## Notes for Permissive path management scheme

### Greenhill documents: GH7.10; APP-554.

Title:
Figure 8.1.1 Site Locations and Study Area
Green Hill A & A.2

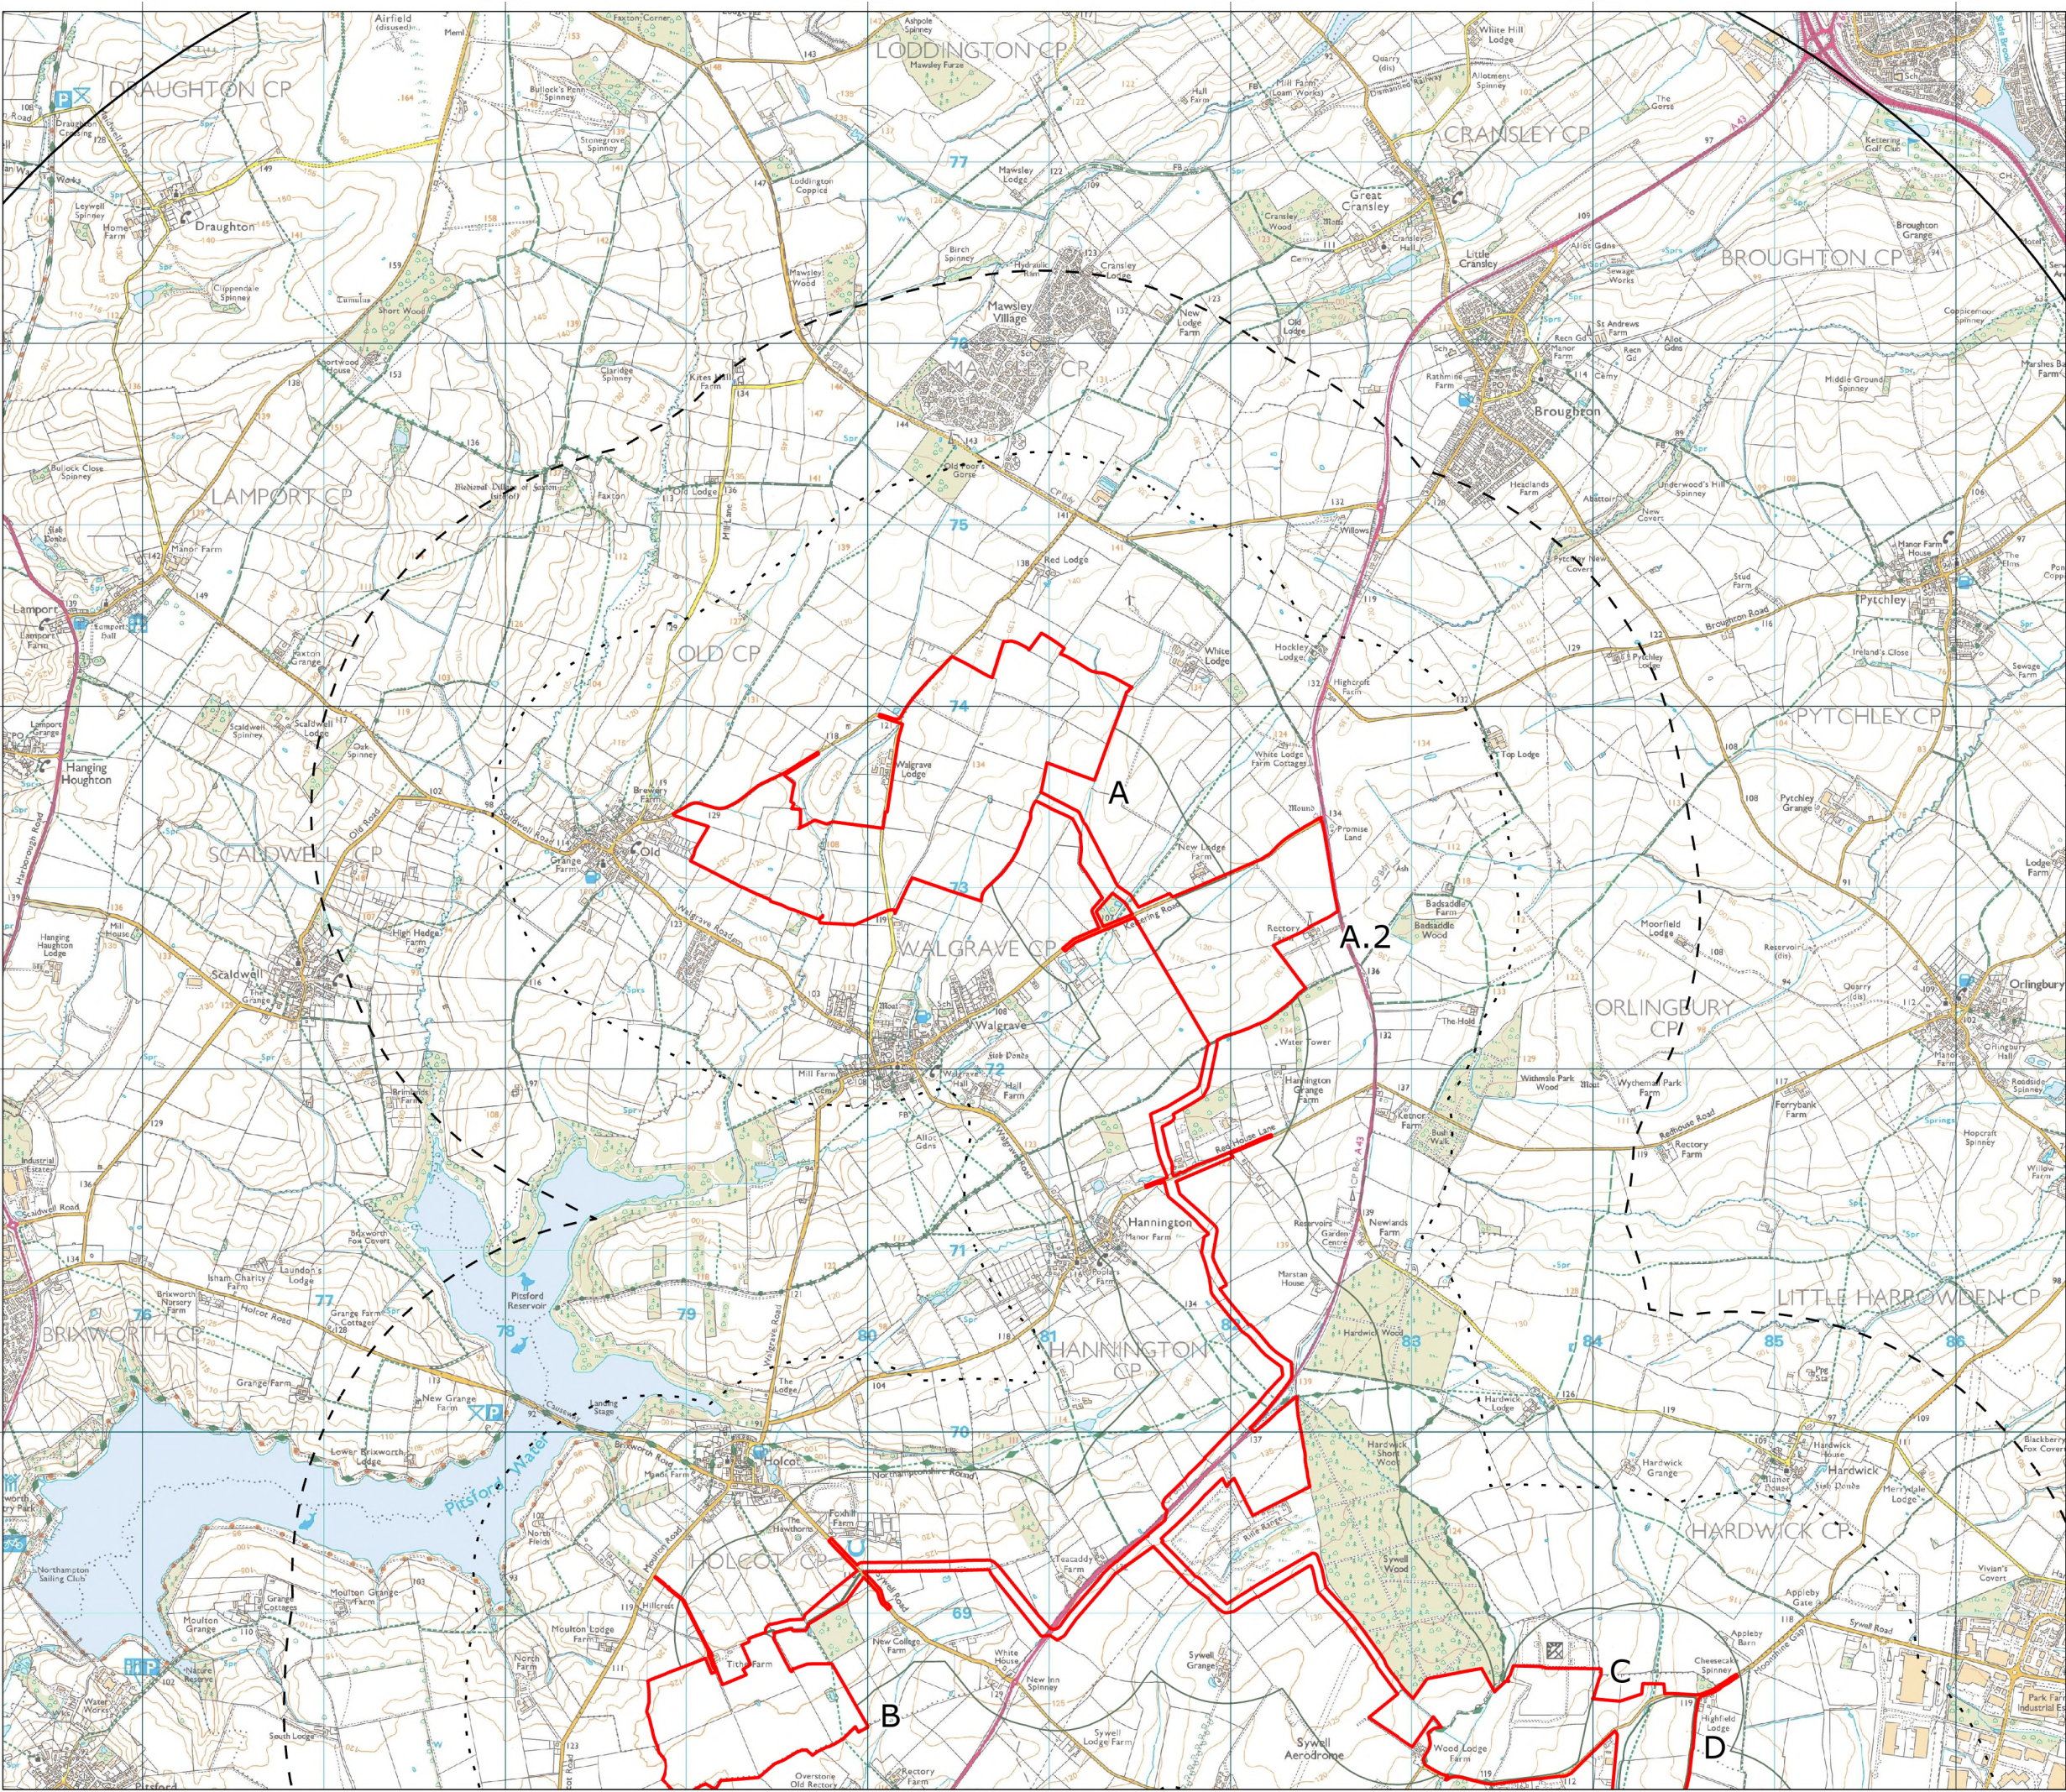
- 8.** This is, effectively repeated at A2 where the proposed permissive path will presumably be impaired by the cable construction for an as yet unspecified period of time.

Title:
Figure 8.1.4 Site Locations and Study Area
Green Hill F & BESS

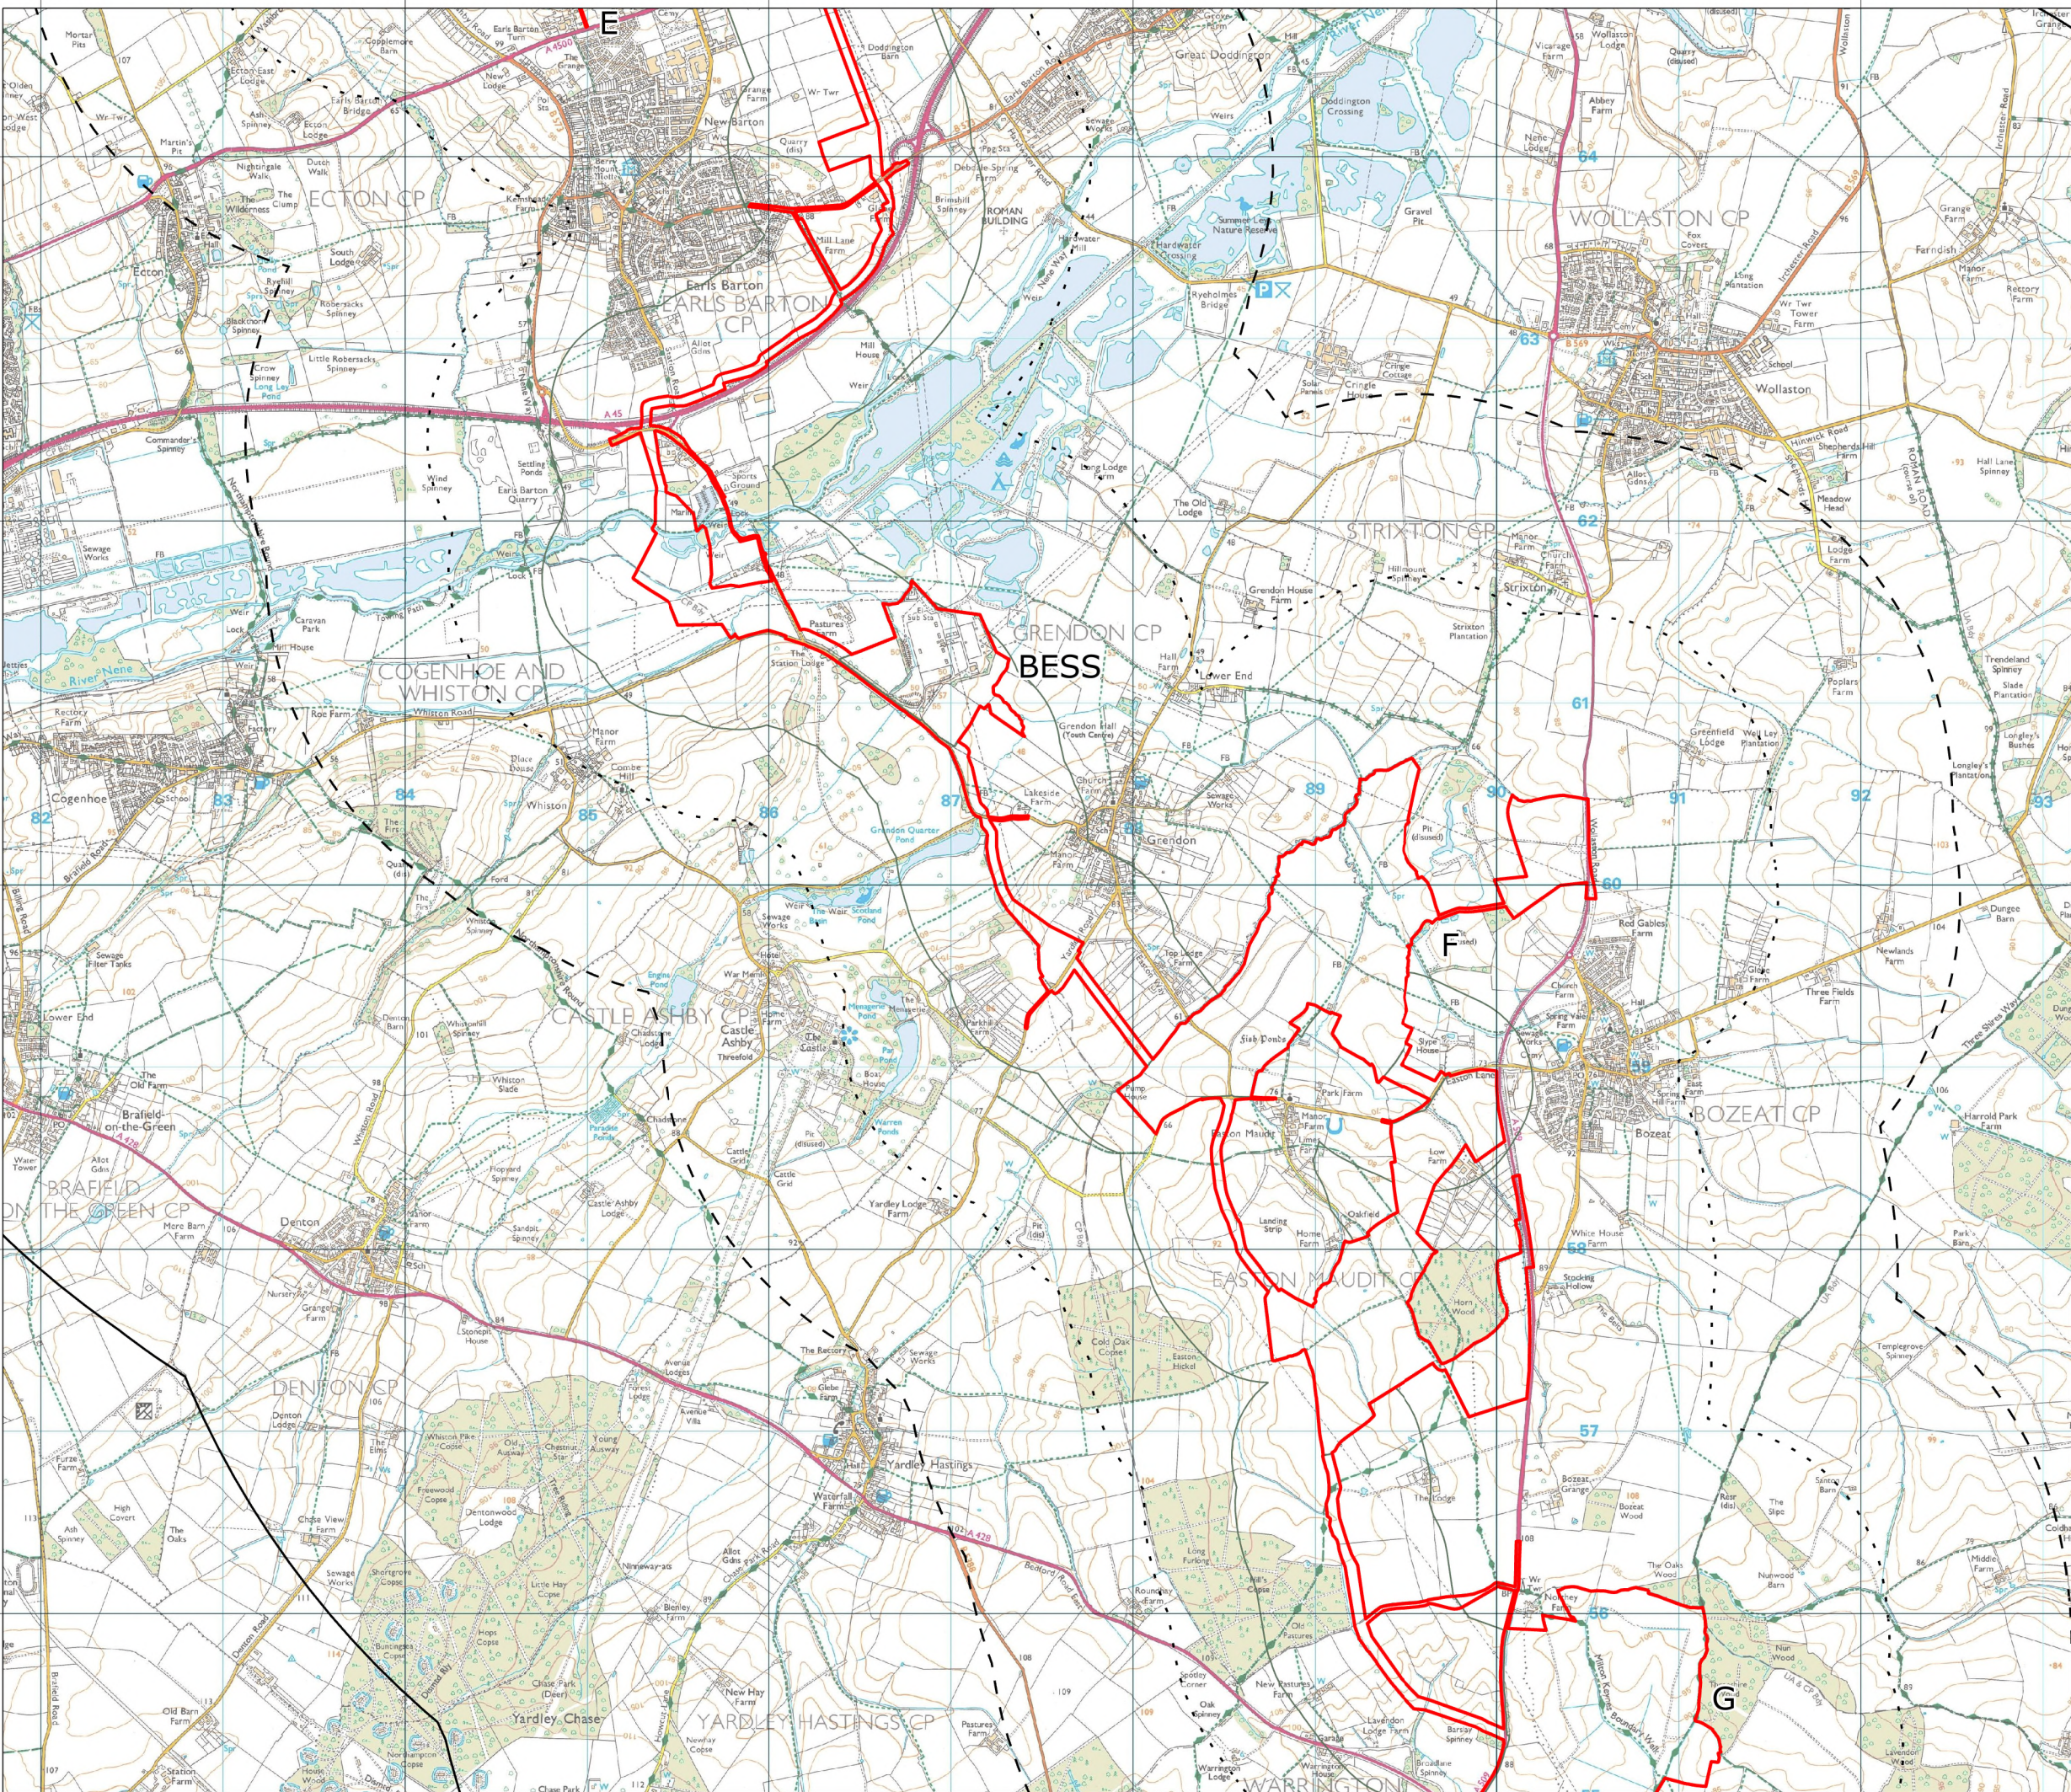
- 10.** Site F highlights the greatest amount of footpath disruption and alteration, exemplifying the replacement of what have been, for generations, open paths across fields. Their substitution with permissive paths requires walkers to walk around solar plantations. The suggestions that connections are improved is not accepted. Fields such as FF28 and FF33 will no longer be country routes.
